Ann Machado - Re: 15 Prince Ave., Peaks Island

I am seeking a permit for the construction or installation of:
enclose side porch, raise she roof on porch, remove load bearing

PROJECT DESCRIPTION:
JEREMY SHERMAN
PEAKS ISLAND, MAINE

3 RIGHT ELEVATION OF NEW RENOVATIONS
SCALE: 1/4" = 1'-0"

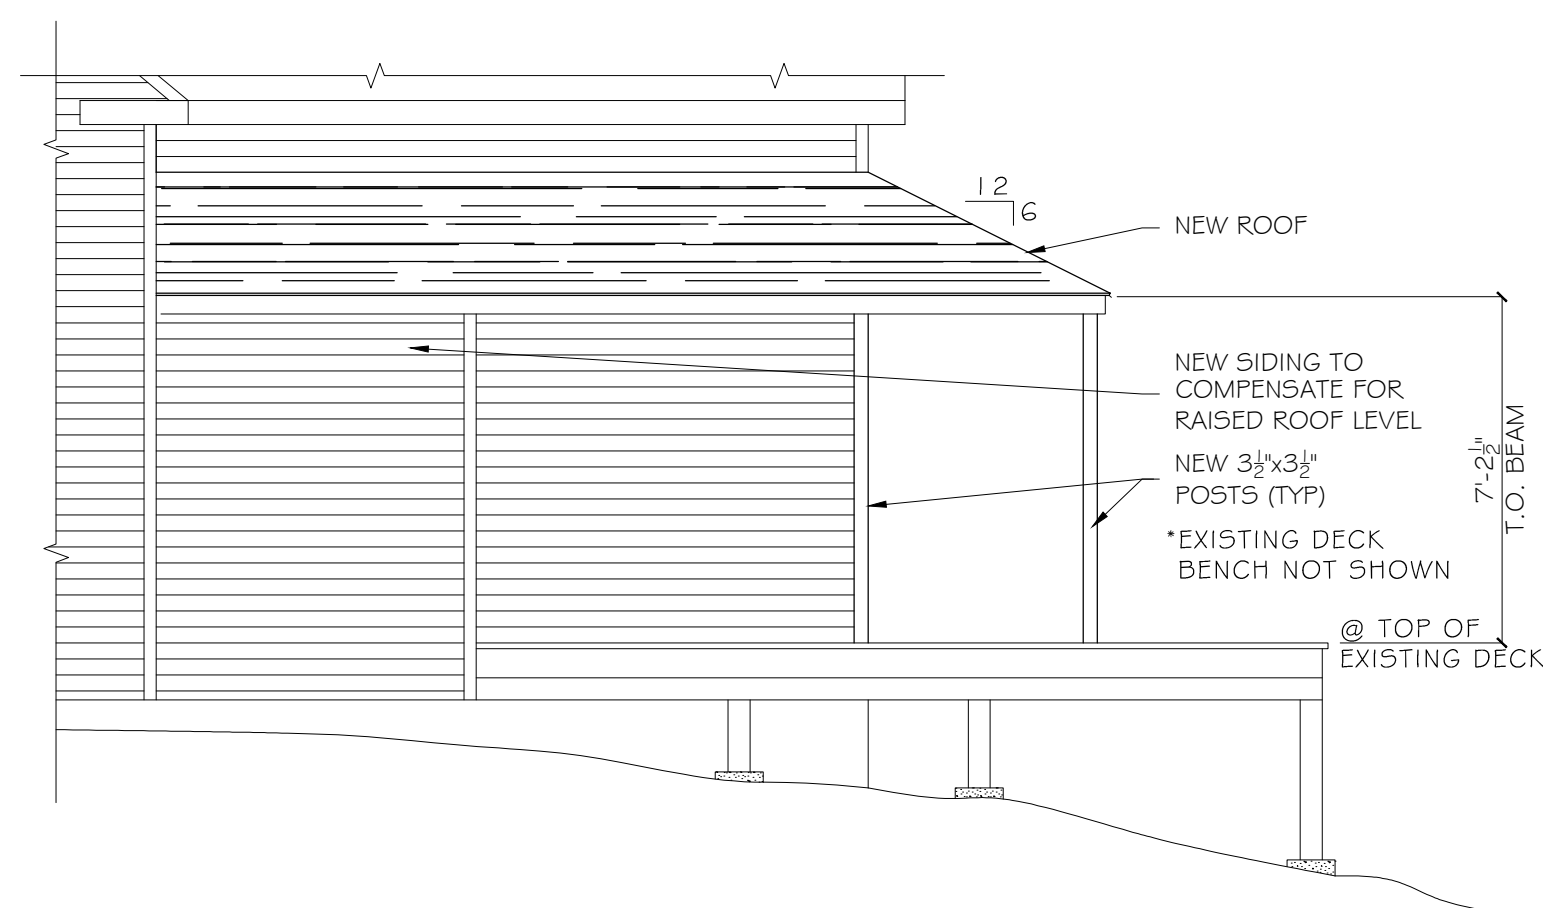
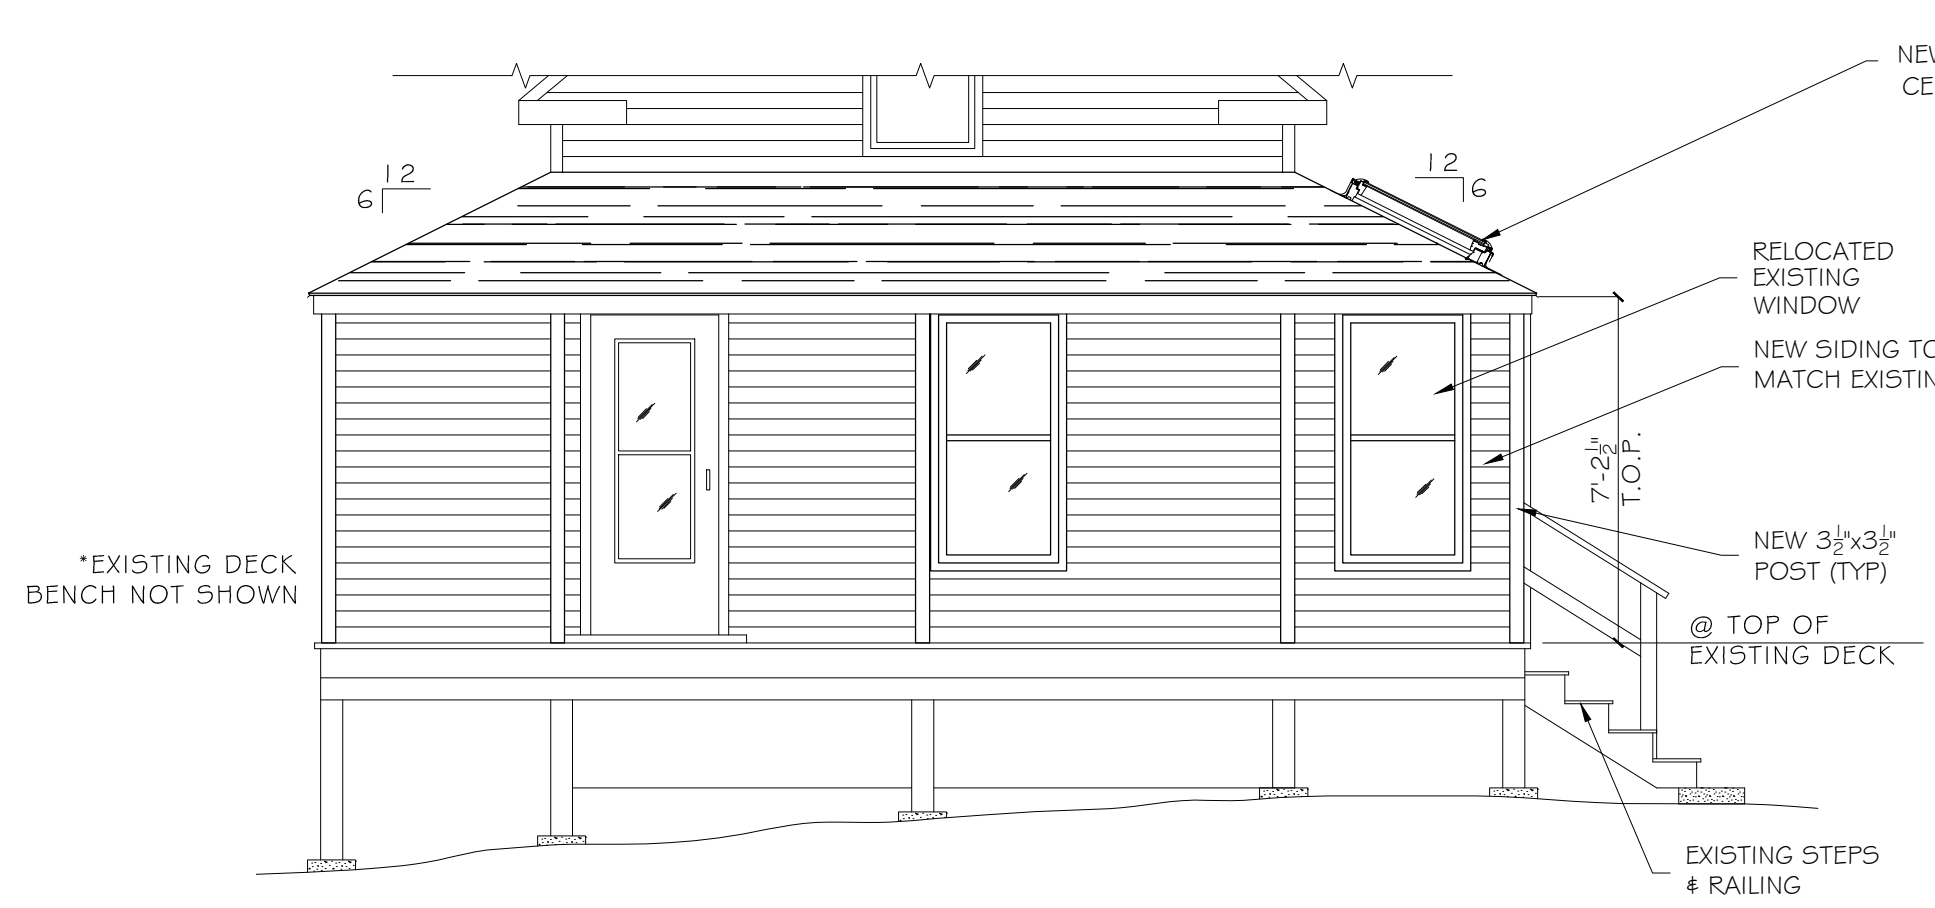
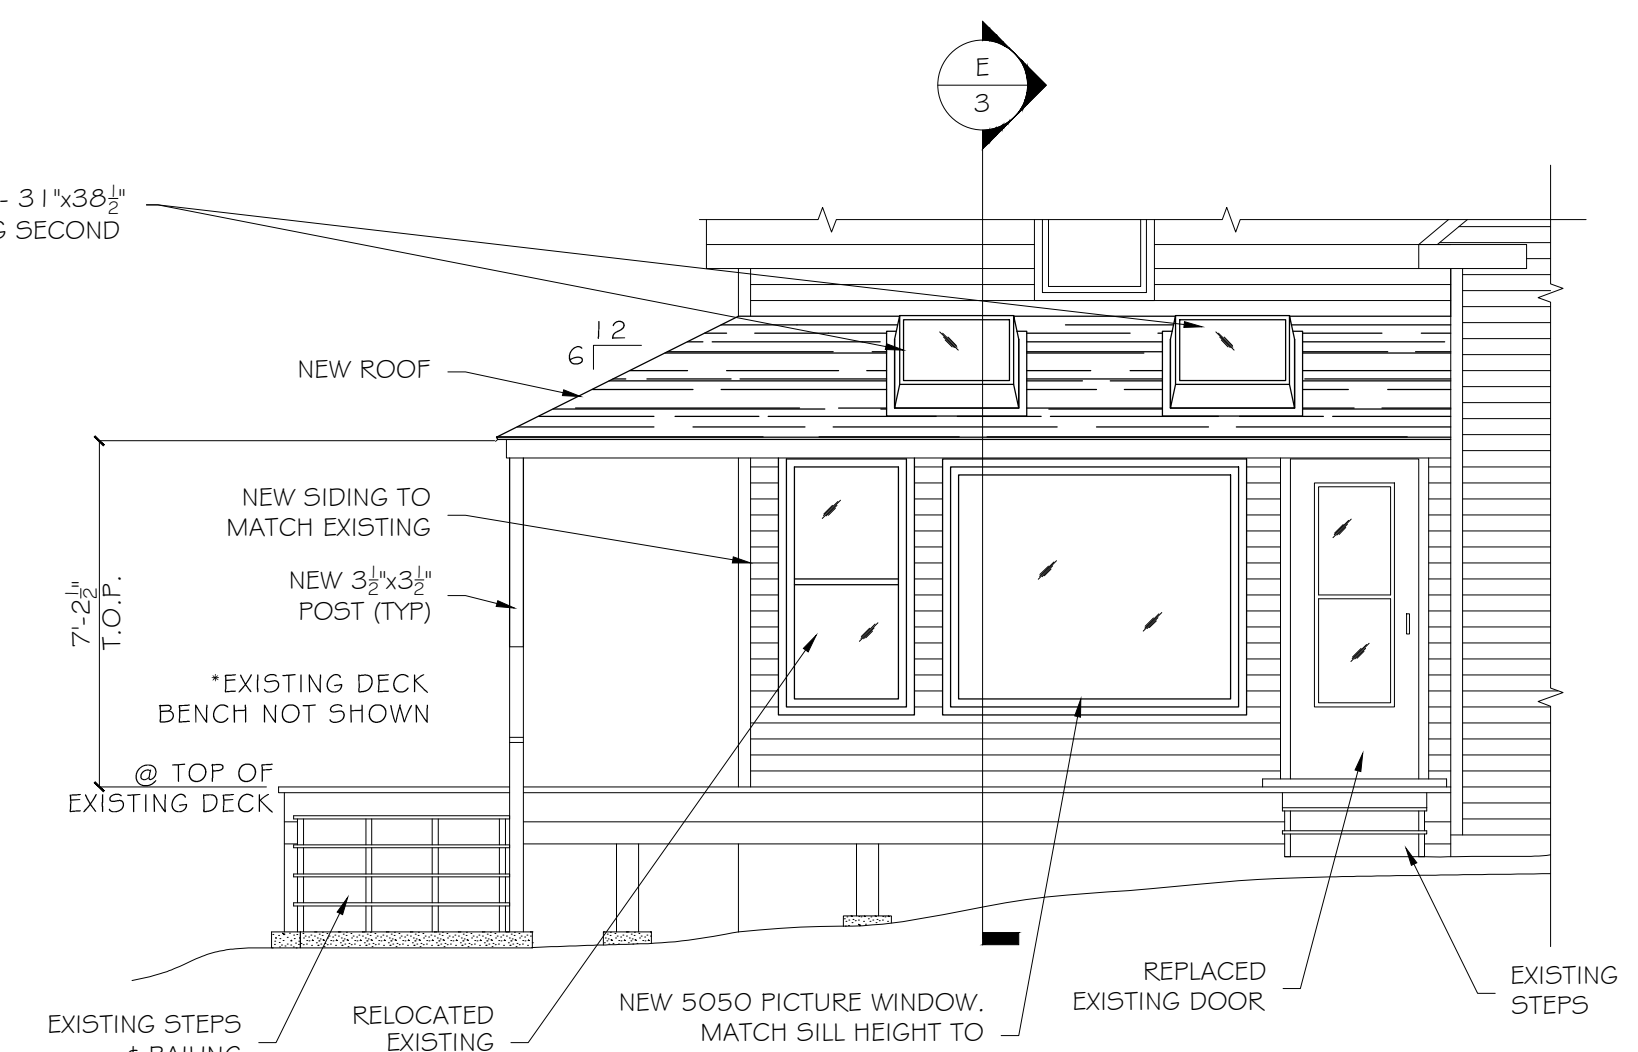
> You said that you would add the second picture window on the same wall as the first picture window. When I look at the right elevation on the plans submitted I don't see how you are going to fit a picture window on that wall.

> > Hi Ann,
> >
> > I have another picture window (61" x 47") that I will also use. I hope that will be enough glass.
> >
> > Jeremy Sherman
> > Sherman's Painting
> > 207-749-6986
> >
> > > On Feb 3, 2015, at 1:25 PM, Ann Machado <AMACHADO@portlandmaine.gov> wrote:
> > >
> > > Jeremy -
> > >
> > > The numbers don't quite add up.
> > >
> > > Section 14-427 states that the porch can be enclosed "if the major portion of the enclosure is glass". The skylights don't count towards the enclosure because they are going on the roof which is already there and not part of the enclosure. The glass (window) area needs to be cover more than 50% of the walls that are being added.

> > > One wall is 14' x 7' = 98 sf. The other wall is 5' x 7' = 35 sf. The total sf is 133 sf. - half of that is 66.5 sf.

> > > The total is 7503 sq in = 52.1 sf. The glass area needs to be more than 66.5 sf.

> > > > > I'm sorry that I did not email you on Monday after we talked. I'm ready to sign off on your permit to enclose the porch. Before I can do that I need you to show that more than 50% of the enclosure is of glass (section 14-427).

If you change out the two 60" x 28" windows for two 4' x 5' (48" x 60"), you would have:

window in the door - 58" x 22" = 1276 sq in
 picture window - 61" x 47" = 2867 sq in
 two double hung - 48" x 60" = 5760 sq in
 -the total is 9903 sq in = 68.8 sf -which is more than 66.5 sf.

You now meet section 14-427.

I just ordered 2 - 4'x5' double hung windows to replace the other 2 windows that I was going to reuse. Add those to the picture window and the glass in the door that should be enough square feet of glass to bring me to 50%.
